Fosse Green Energy
Development Consent Order 202[]

Statement of Common Ground Between
Fosse Green Energy Limited and Phillips 66 Limited

Deadline:	
Planning Inspectorate Scheme Reference:	EN010154
Document Reference:	EN010154/EXAM/8.14
Author:

FIGURE TITLE
400KV PIPELINE CROSSING
FIGURE NUMBER
Figure 1-1
DOCUMENT REFERENCE
EN010154/APP/X.X

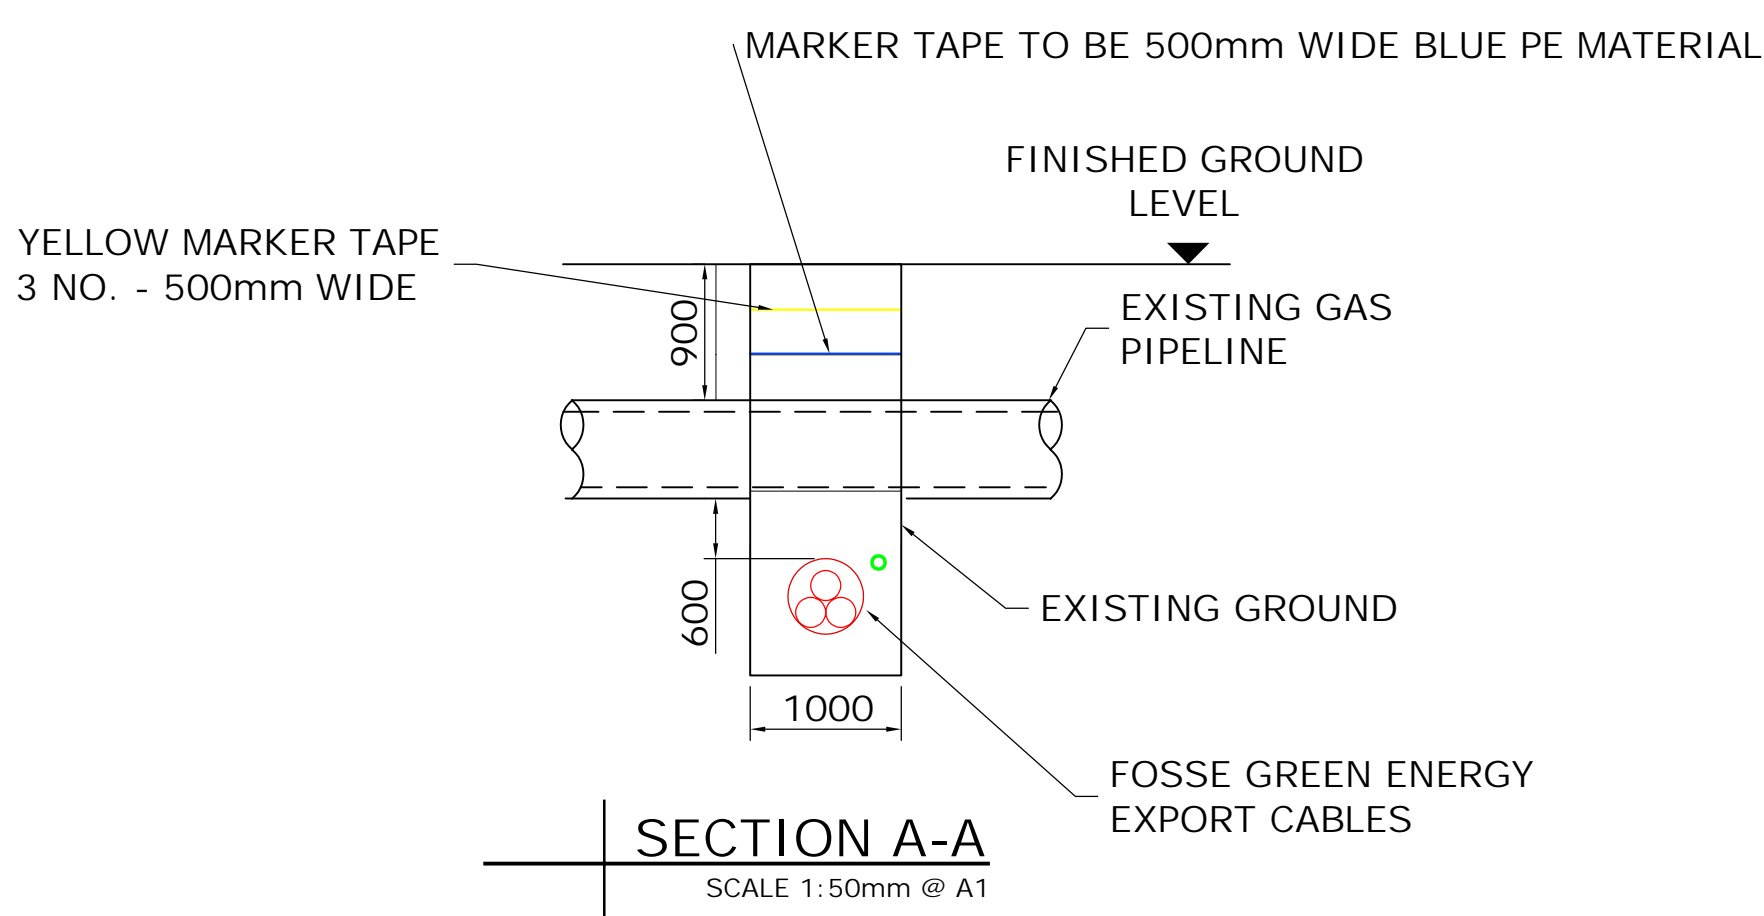
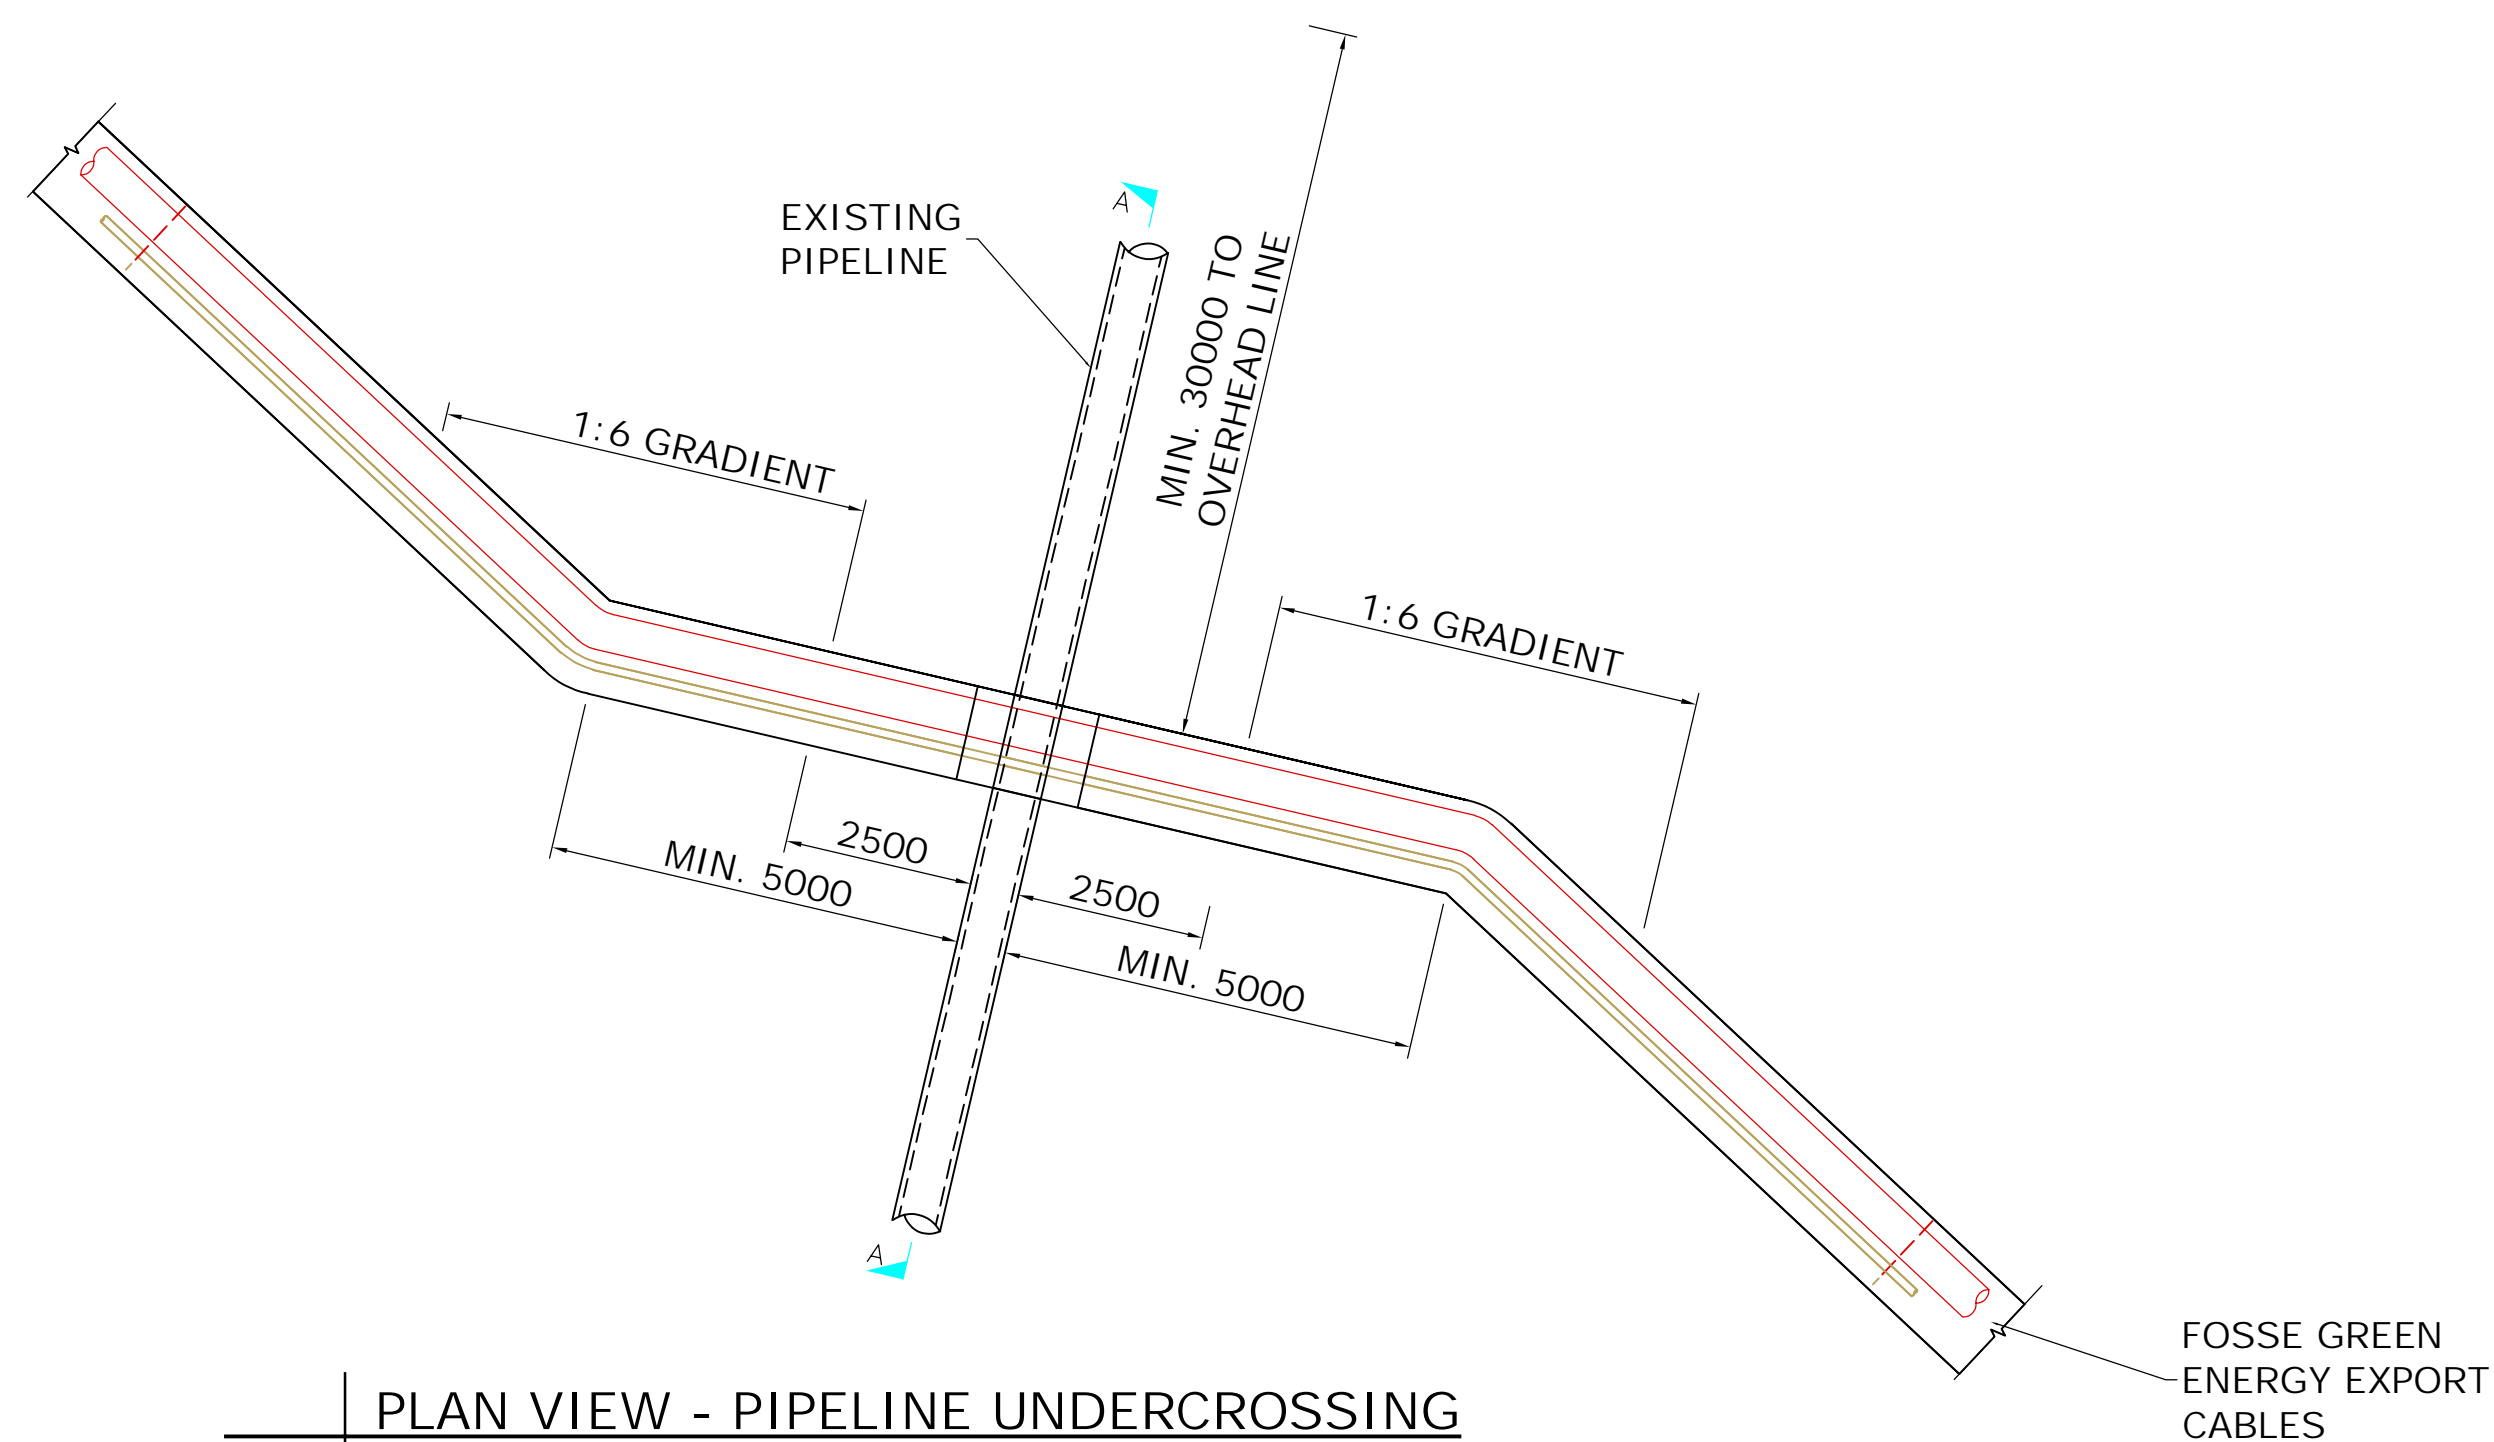
- 1.1.10 Draft Crossing Details were sent by the Applicant to BPA, as part of the Updated Risk Assessment, on Friday 24 April 2026 at 16.24. The Final Risk Assessment, sent by the Applicant on 27 April 2026, contained updated Crossing Details. The draft Crossing Details incorrectly refer to a gas pipeline. The draft Crossing Details are approved in principle provided that reference to the gas pipeline is corrected and subject to final approval by P66.

15/04/2025	Email	FF query the angle of the crossing which does not look to be 90 degrees.
15/04/2025	Email	The Applicant confirms that the crossing is at 90 degrees.
16/04/2026	Email	BPA suggested a meeting 22 nd April 2026 to discuss the updated AC Interference Modelling Study (or Risk Assessment).
16/04/2026	Email	FF provide WBD with updated draft PPs following receipt of the slightly updated report by Prax.
16/04/2026	Email	WBD confirms receipt of the revised draft PPs and requests copies of the documents listed under "the Prax requirements" in the draft PPs so that these can be reviewed in parallel to the draft PPs.
17/04/2026	Email	BPA provided the documents requested by WBD.
